Comments for Planning Application 20/01296/OUTMAJ

Proposal: Outline application for up to 41 dwellings (30% affordable), public open space and associated infrastructure with access applied for off School Lane (all other matters reserved)

Commenter Type: Member of the Public

PROPOSED FOOTPATH CONNECTION ON SCHOOL LANE @1:200

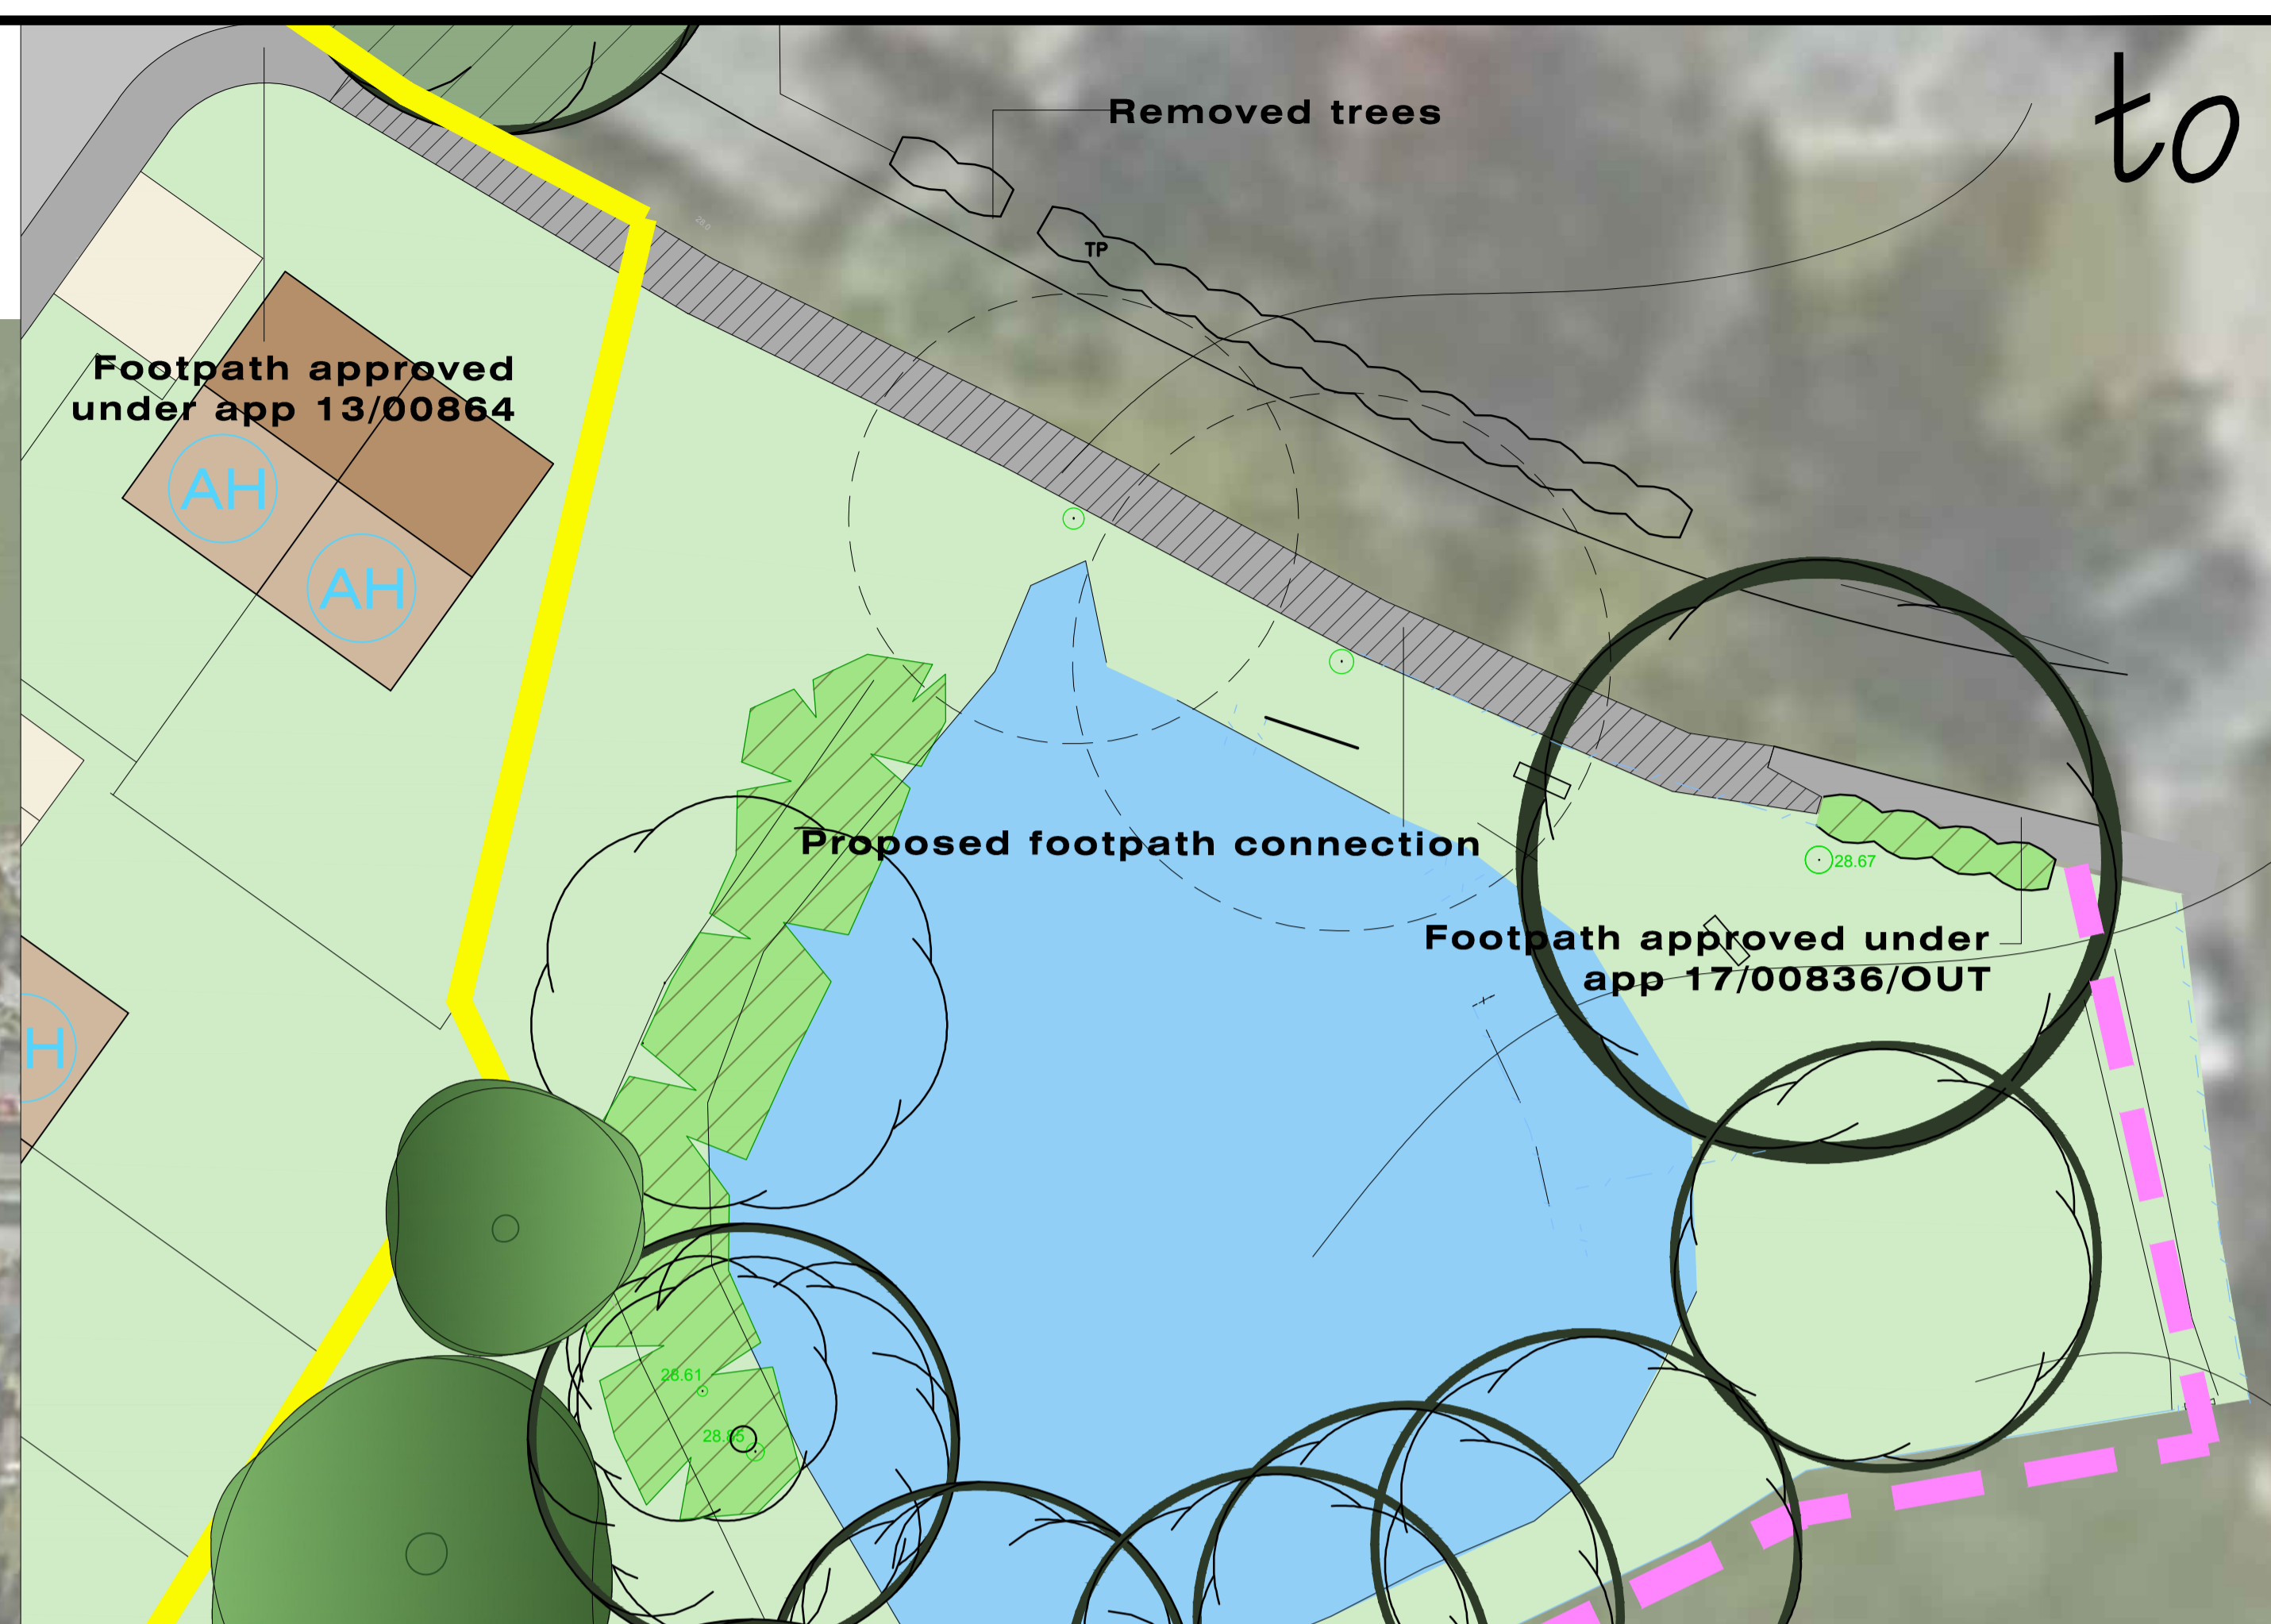
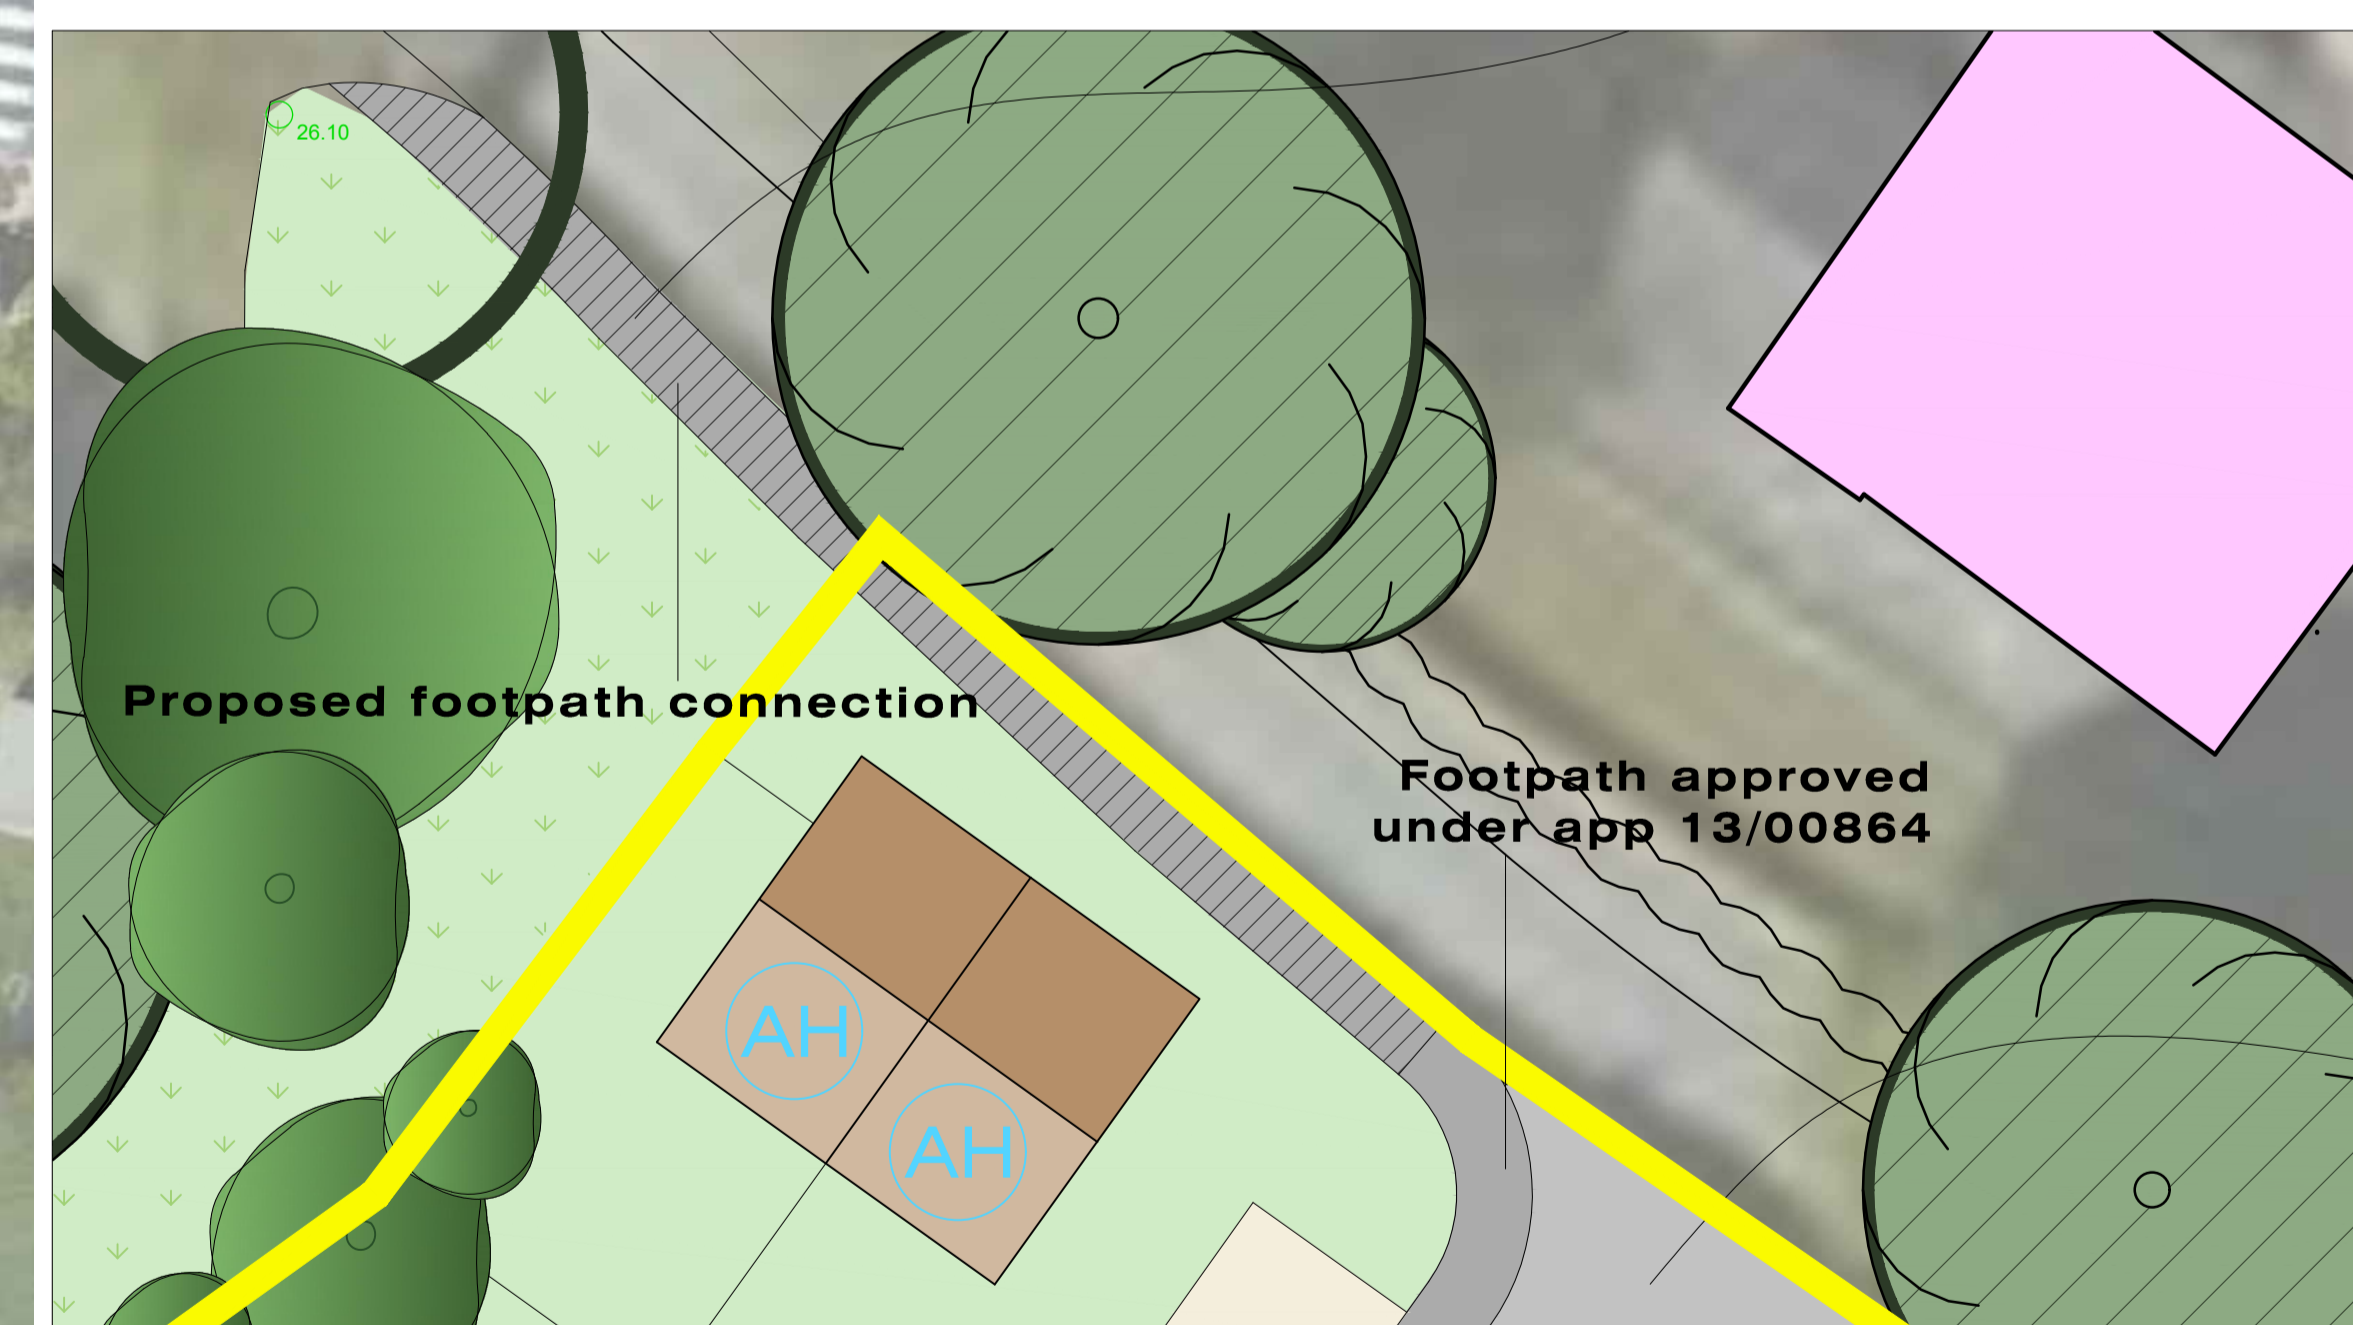
If approved this would add further stress to our village in regards to an increase in traffic. School lane would be the access road which is too narrow, very unkept, poor lighting and unsafe for pedestrians as it is. I have experienced this first hand and seen many close calls with vehicles and pedestrians on this road.

The proposed pavements do not change the fact the the road is too narrow and will directly affect the privacy of the houses along school lane.
